**KIRKLEES METROPOLITAN COUNCIL  
INVESTMENT & REGENERATION SERVICE**

**DELEGATED DECISION FOR DISCHARGE OF CONDITION -  
NOTIFICATION OF A CHANGE OF USE UNDER THE ABOVE  
PROVISIONS**

Reference no.	<b>2026/CL/90270/E</b>
Site Address	<b>Scissett Mount Nursing Home, Busker Lane, Scissett, Huddersfield, HD8 9JU</b>
Description	<b>Prior approval for installation of solar photovoltaic (PV) panels and associated works</b>
Recommending Officer	<b>Nicole Helliwell</b>

**DECISION - REFUSED**

Project:	Busker Lane, Scissett
Client:	TLC Care Group
Title:	Existing and Proposed Roof Plans
Date:	13.01.26
Drawn:	RM
Check:	DB
Scale@A1:	1:200
Revision:	P01
Status:	Planning

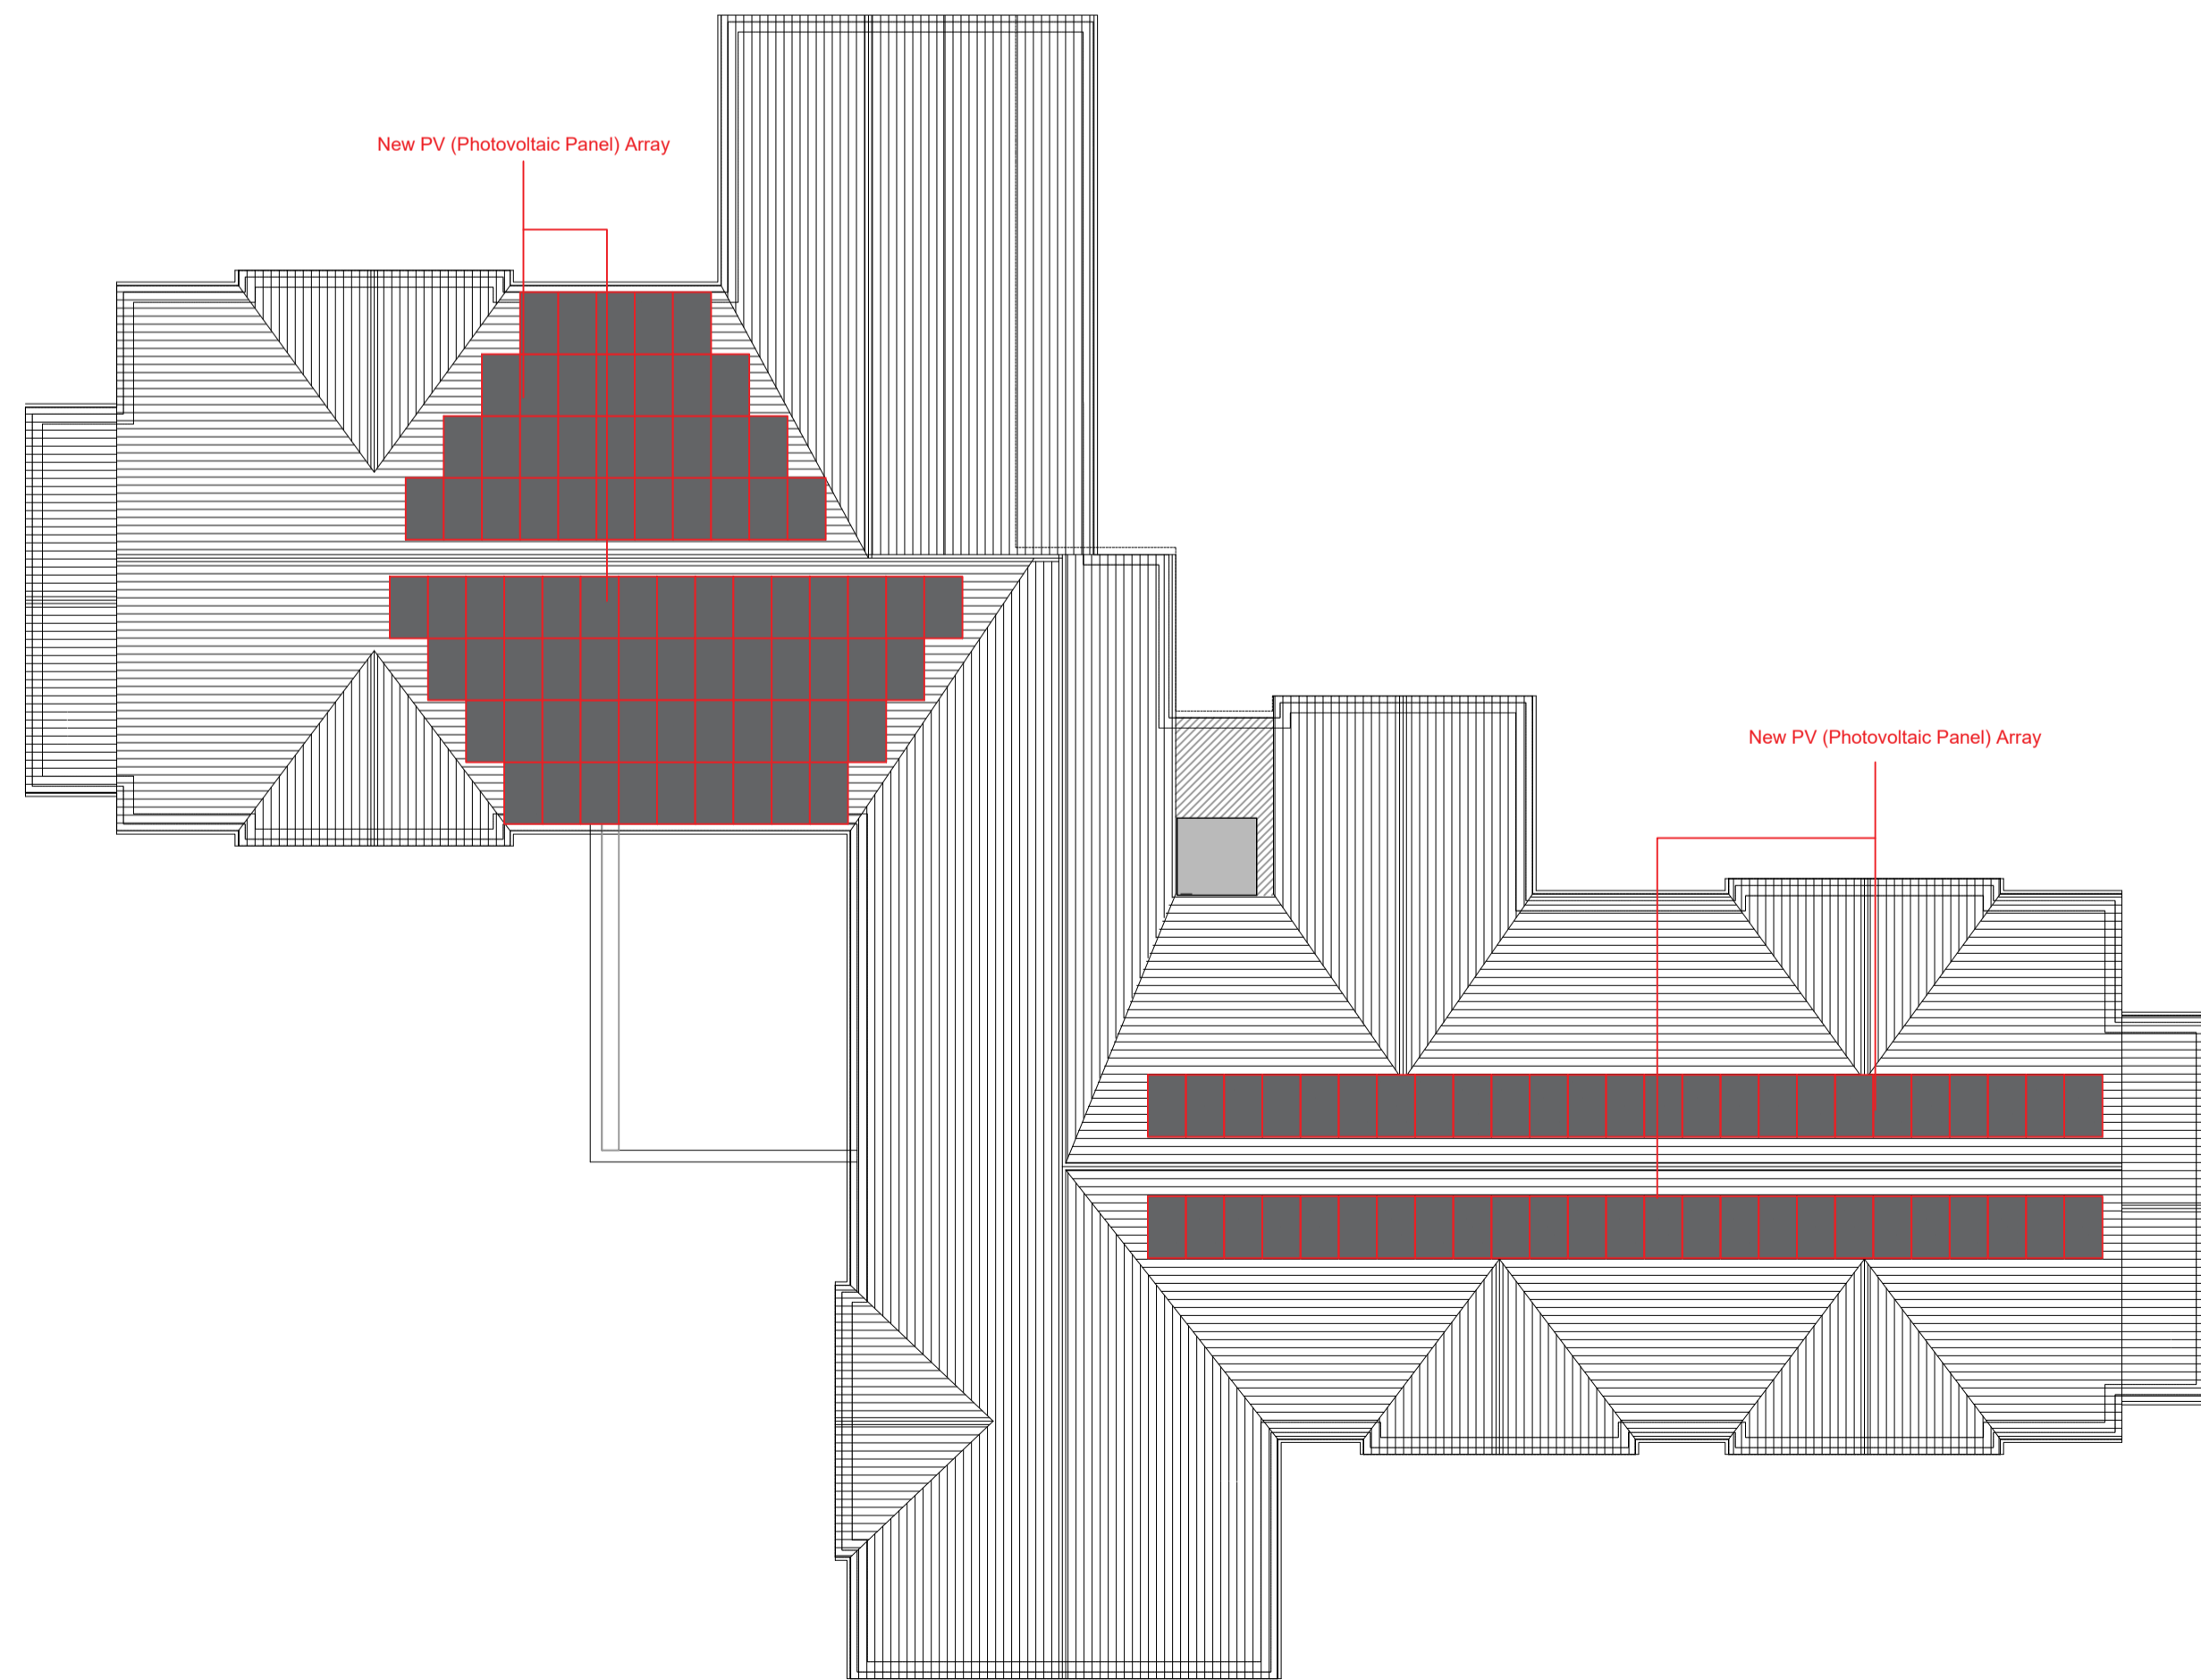
**Comment:** *The application form states that the panels would not be within 1 metres of the external edge of the roof. However, the submitted roof plan clearly demonstrate that the panels would be installed within 1 metre from the edge of the roof and would therefore fail to comply with the limitations under Paragraph (c).*

On this basis, it is concluded that the proposal is not permitted under Part 14, Class J of Schedule 2 of the Town and Country Planning (General Permitted Development)(England) Order 2015 (as amended) as the panels would be sited within 1 metre from the external edge of the roof slope and is therefore recommended for refusal.

Development)(England) Order 2015 (as amended) as the solar panels as shown on submitted plans would be installed within 1 metre of the external edge of that roof.
